Kirklees Direct
Tel: 01484 414746
Email: lucy.taylor@kirklees.gov.ukT Amin
49, Birkby Lodge Road
Birkby
Huddersfield
HD2 2BEDate: 17-Nov-2020
Our Ref: 2020/93242

TOWN AND COUNTRY PLANNING ACT 1990
TOWN AND COUNTRY PLANNING (GENERAL PERMITTED DEVELOPMENT) (ENGLAND)
ORDER 2015 – SCHEDULE 2, PART 1, CLASS A.1 (g)
AT: 49, Birkby Lodge Road, Birkby, Huddersfield, HD2 2BE
Prior notification for single storey extension

PROPOSED GF floor

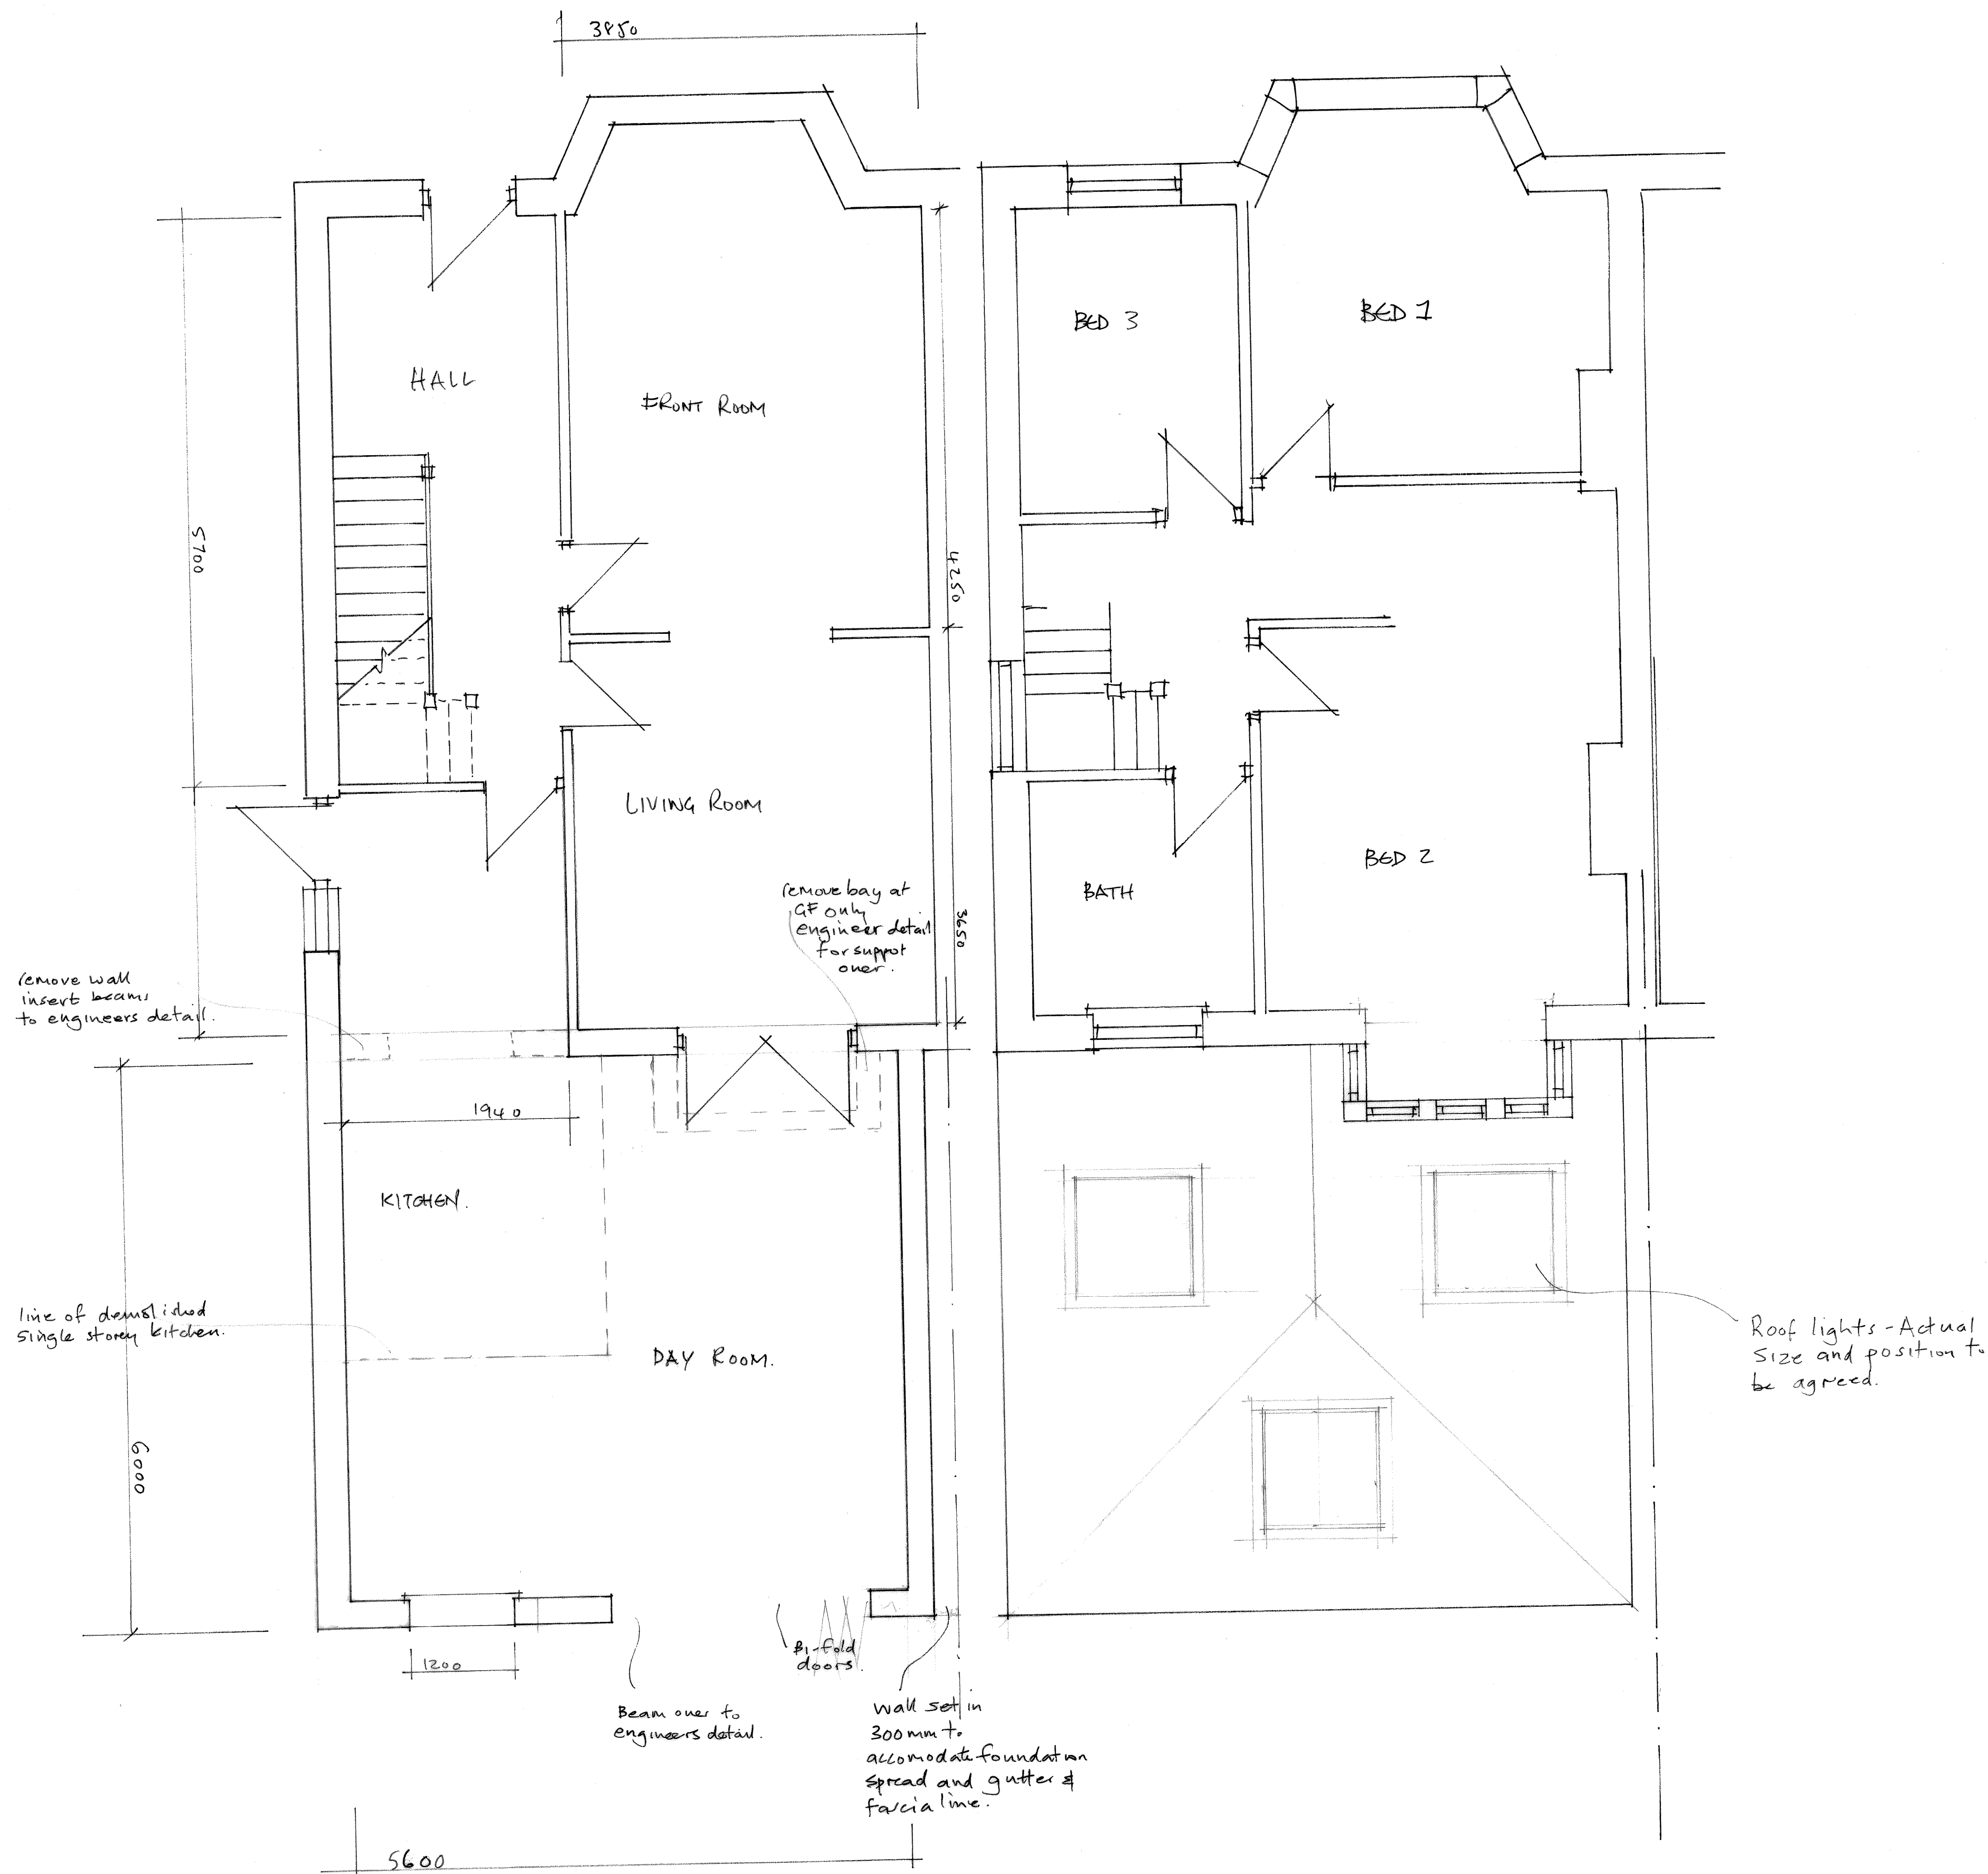
You are advised that historical imagery held by the Council shows the existing rearward projection to be an original part of the dwellinghouse. As such, the side wall of the projection would be considered an original side wall and the proposed development extends beyond this side wall. As a result of this the proposal is more than half the width of the original dwellinghouse and therefore is contrary to paragraph (j) of Class A, Part 1 of Schedule 2 of the Town and Country Planning (General Permitted Development)(England) Order 2015(as amended).

Consequently and while you have not been notified of prior approval in accordance with condition A.4 of Class A, the development cannot be considered to benefit from a general planning permission under the General Permitted Development Order and therefore requires full planning permission upon application to the Local Planning Authority.
